From: Michael Eastham <Michael.Eastham@arun.gov.uk>
Sent: 17 December 2019 12:39
To: Planning.Responses <Planning.Responses@arun.gov.uk>
Subject: FW: Littlehampton: CEMP Rev B - LU/339/19/DOC and LU/340/19/DOC

From: Roger Spencer <Roger.Spencer@arun.gov.uk>
Sent: 17 December 2019 12:37
To: Michael Eastham <Michael.Eastham@arun.gov.uk>
Cc: Paul Cann <Paul.Cann@arun.gov.uk>
Subject: RE: Littlehampton: CEMP Rev B - LU/339/19/DOC and LU/340/19/DOC

I think it would be fair to say that the Plan is a little light; however, I can see that several of the issues that would bulk it out are listed as (paraphrased) “to follow” – e.g. Waste Management Plan. I am not sure if you would normally expect to see this included at this stage and for this CEMP to be fully matured at this point.

ii. Traffic Routes Offsite

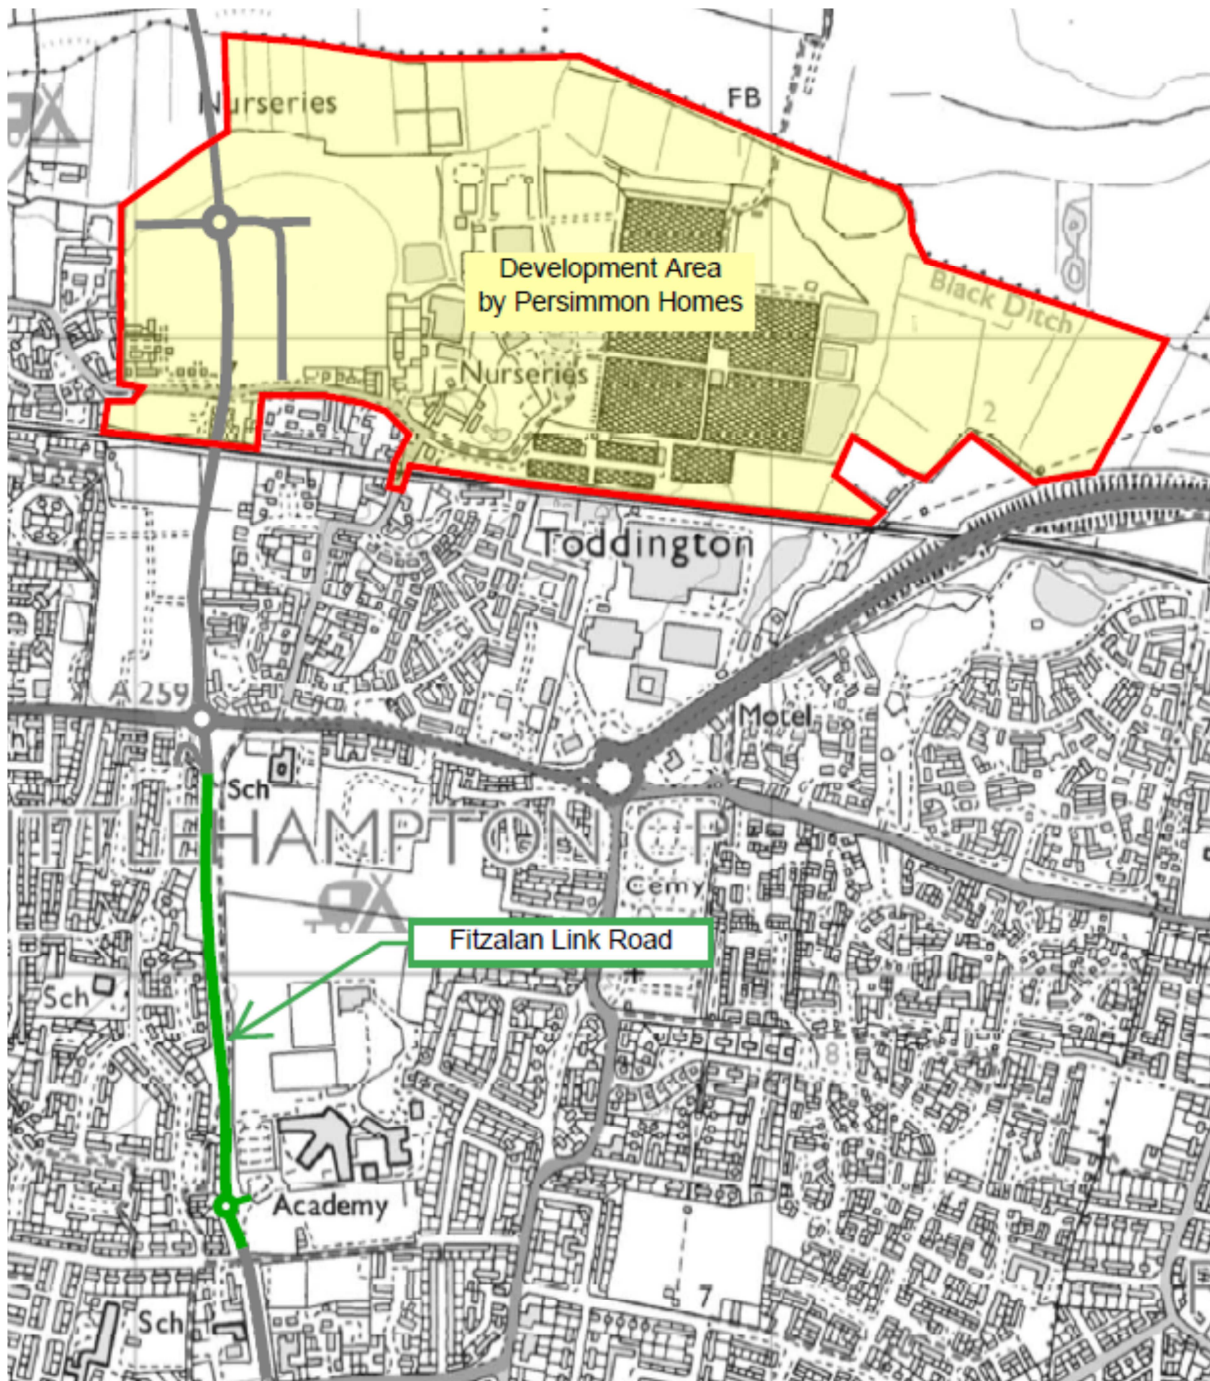
36 a ii speaks of HCC not WSCC
